Epping to Thornleigh Third Track Proposal. Application number SSI 5132.

I/we object to the Epping to Thornleigh Third Track Proposal and consider that the EIS is inadequate and does not address the full impact of this proposal. It will cause untold damage to the health of residents and to the fabric of the Beecroft Cheltenham Heritage Conservation Area. Do not approve this project, reconsider the alternatives and protect the community.

Drawing Operational L_{Amax} Noise Contours Ten Years After Opening (Year 2026)		
										Date 26-07-2012	Drawing Number 610.10578_ETTT016	Revision 1
										Scale 1:2500

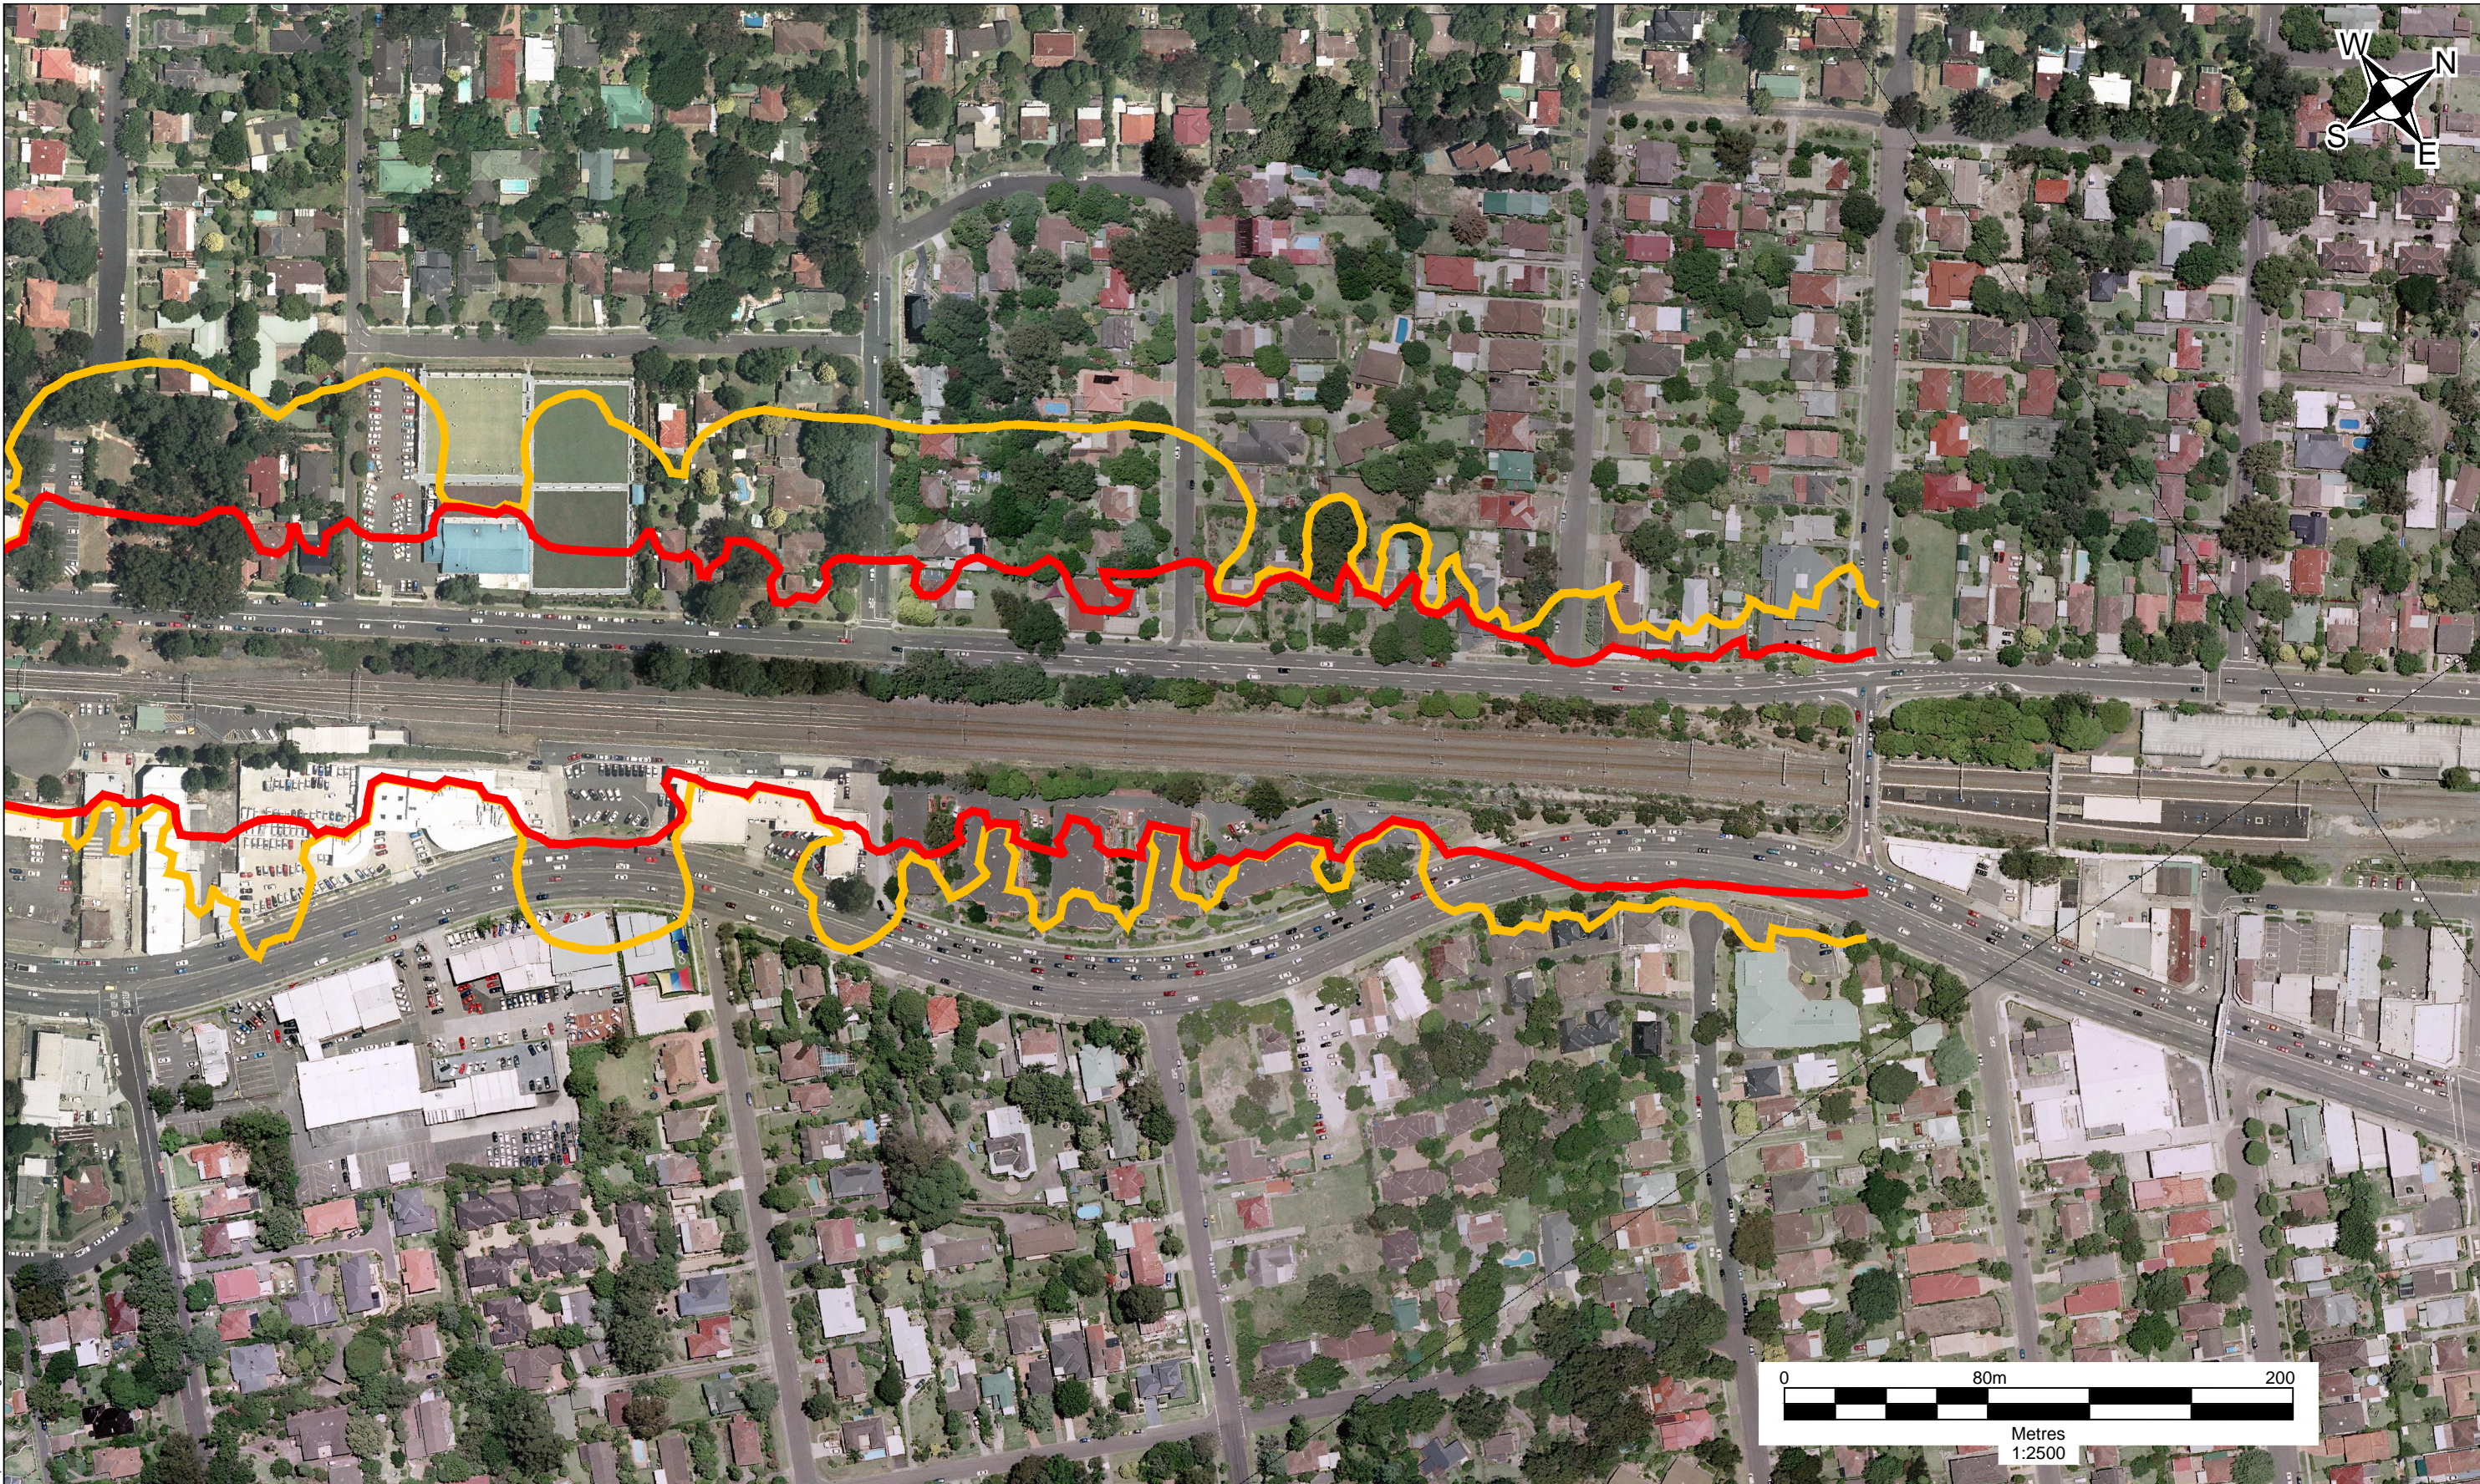
- The EIS does not address the impact on noise of the real potential increase in rail freight traffic beyond the current projected increase from 29 to 41 movements a day thereby avoiding the legislated need for a reassessment of noise levels.

- An independent study has shown current rail noise levels result in some 2 to 3 sleep disturbances a night where 1 is normal for reasons other than noise. Noise frequency will increase with increased traffic and is unacceptable.

- The same study showed that highest noise levels peaks occurred between 10pm and 6am, seven days a week.
- Sleep disturbance is recognised as a significant stress factor which impairs health and wellbeing.

The EIS has not adequately considered any future potential increases in rail freight traffic above the current estimate of 41 movements a day. This is likely to occur with the ETTT and any further increase would require a total reassessment of the project.
